Response to TIS Comments – Honor Charter School – El Paso County, CO

Kellar Engineering (KE) comment responses in **blue** font.

Figure 6: Trip Distribution

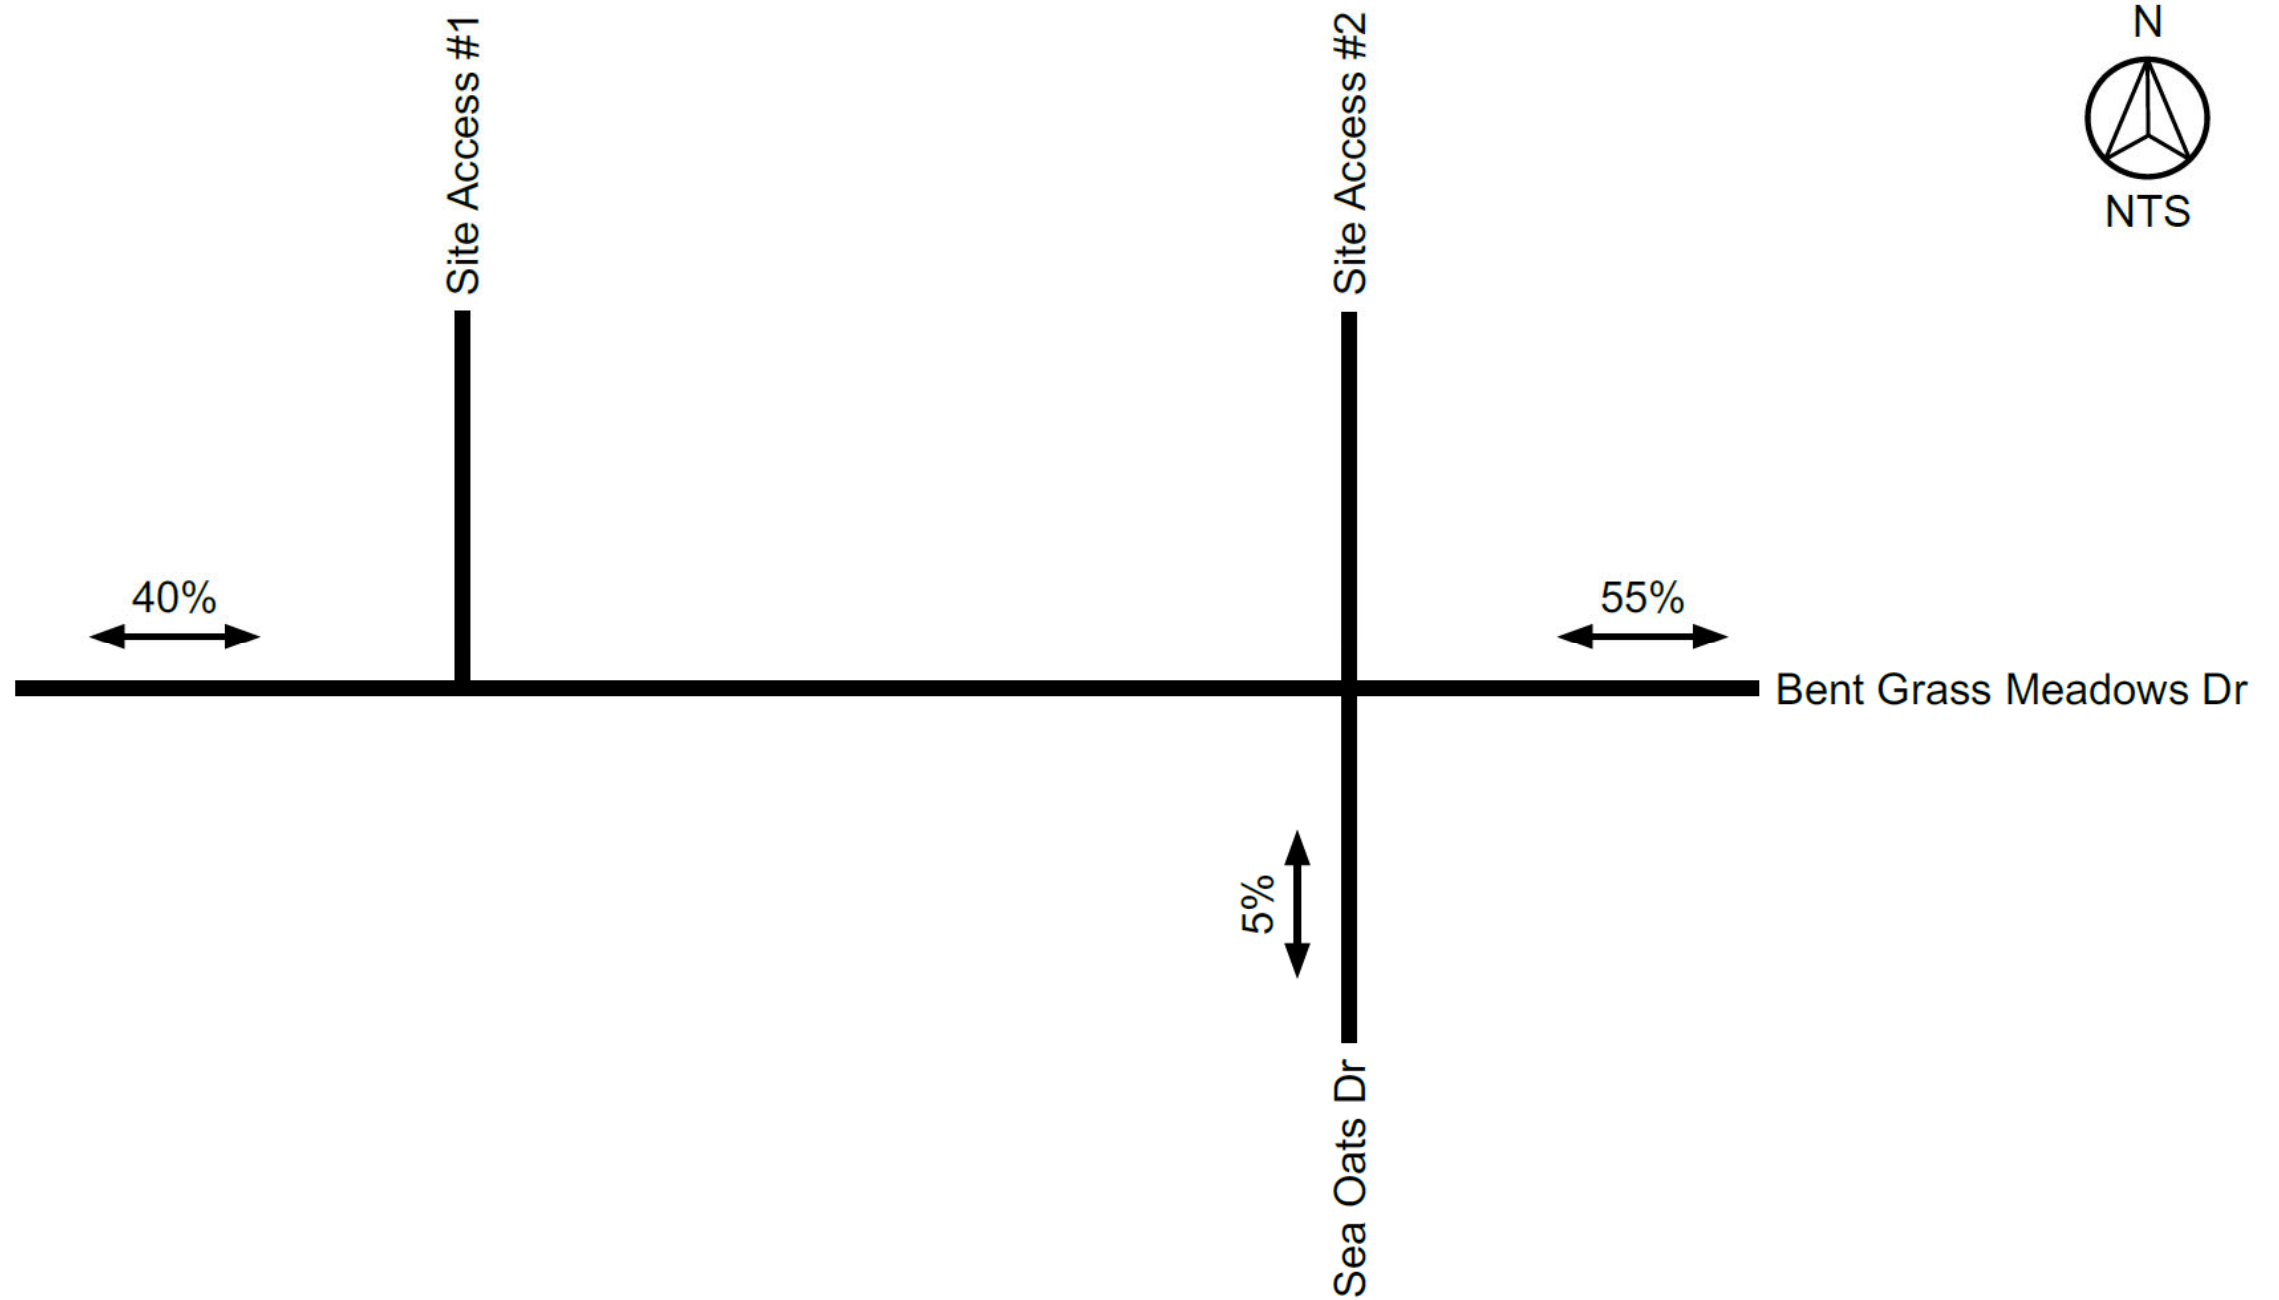
1. Trip Distribution from Bent Grass Meadows westbound to site in Figure 6 on the previous page is 55%. Distribution from Meridian Rd from the south and north should equal 55%. Please revise.

Response: The TIS has been updated accordingly.
